Recommendation Report for Planning Permission

REF NO: LU/303/20/PL

LOCATION: Toddington House
Toddington Lane
Littlehampton
BN17 6JX

PROPOSAL: Lean-to storage extension. This application affects the setting of a listed building & is in CIL Zone 2 (Zero Rated) as other development.

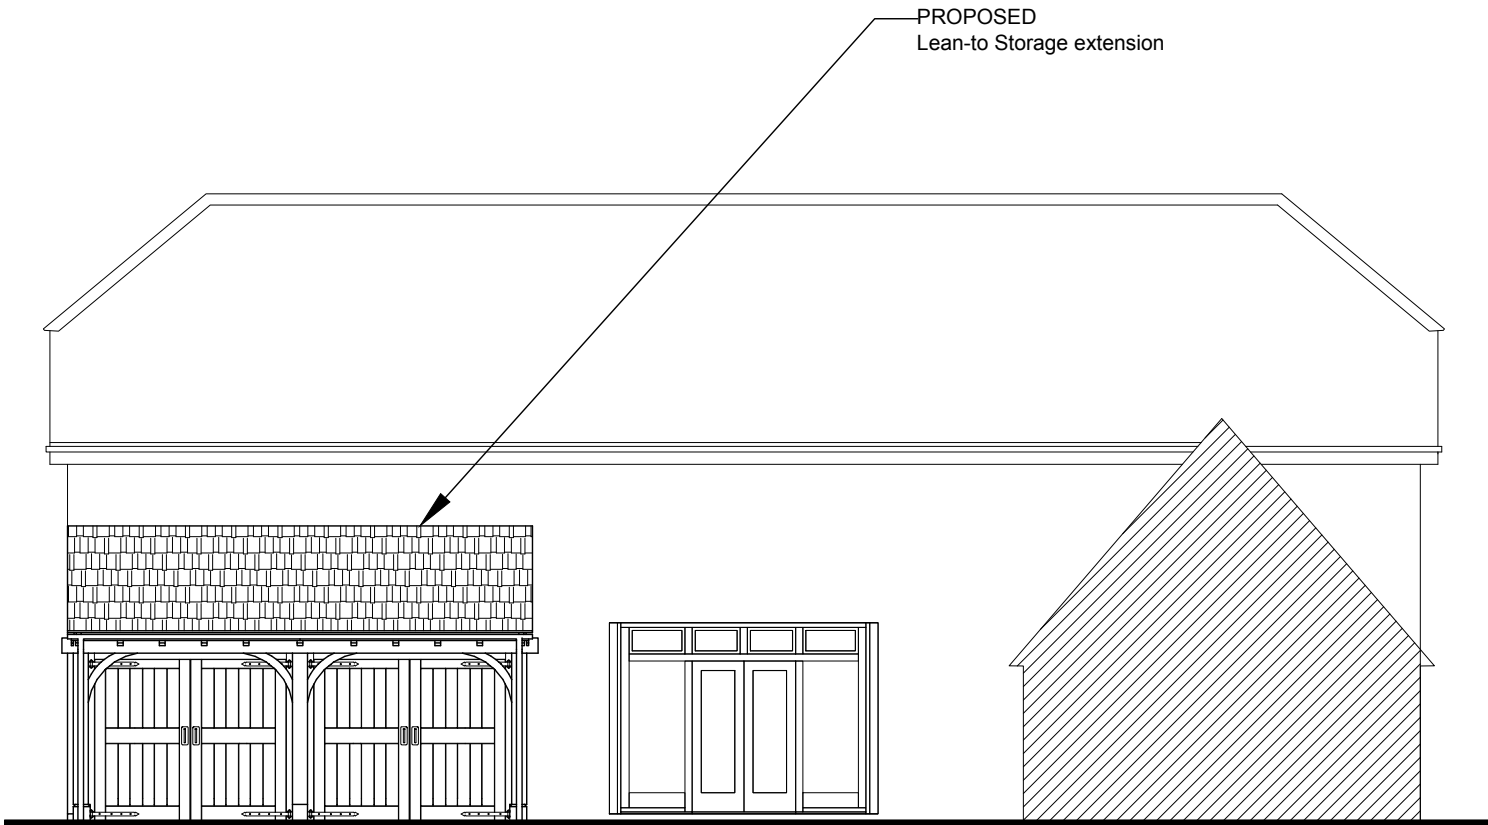
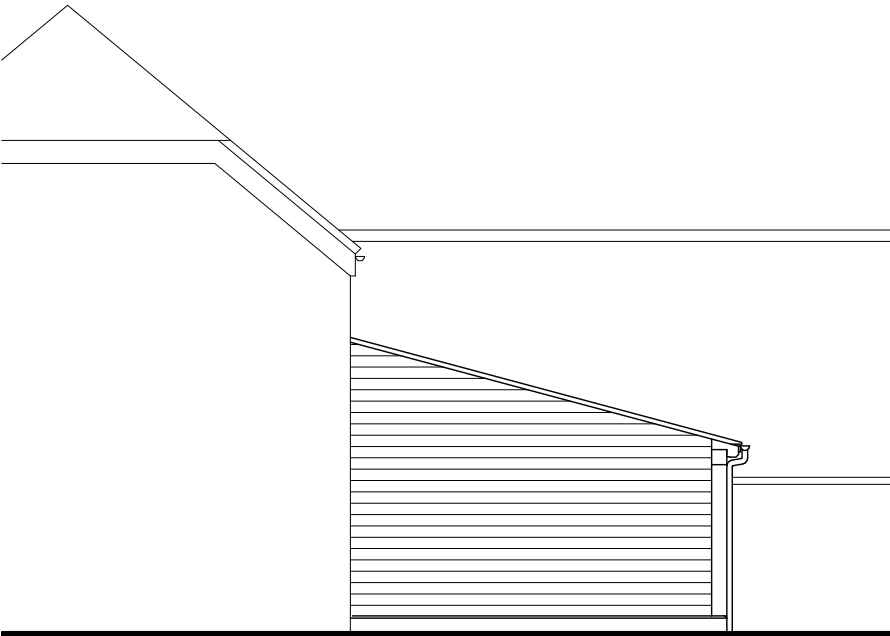
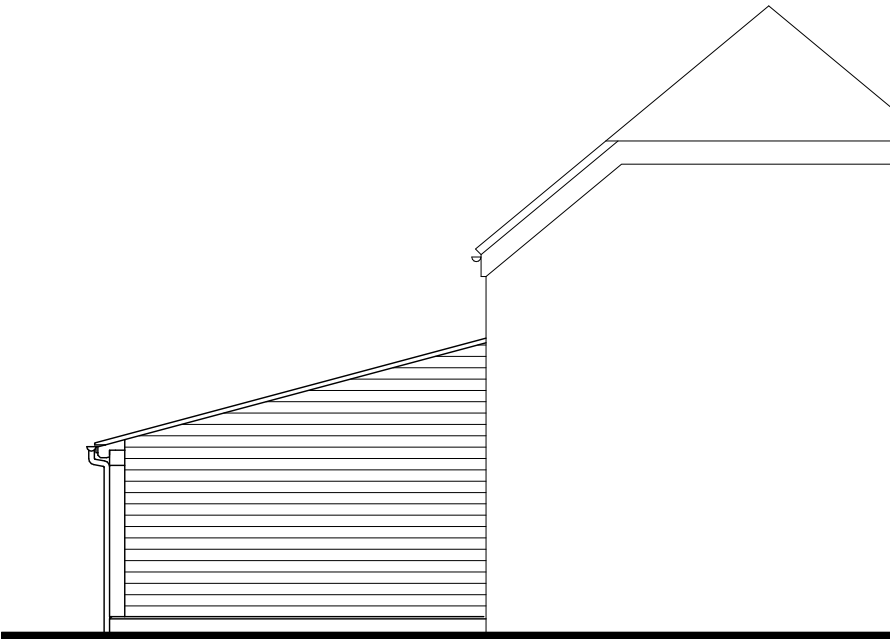
DESCRIPTION OF APPLICATION	As above. The lean to structure would measure 6.10 metres across projecting 4.83 metres from the exterior wall of the barn with an eaves height of 2.6 metres and a height at the adjoining wall of 3.8 metres.
SITE CHARACTERISTICS	A barn converted into an office within the grounds of a Listed Building.
CHARACTER OF LOCALITY	A predominantly residential area.
None relevant.

The proposed design of the extension is to be of sympathetic materials namely an oak framed building with reclaimed clay tile roof, commensurate with its location abutting a traditional barn type structure. The extension would be subservient to the existing building being of a smaller size and scale to it.
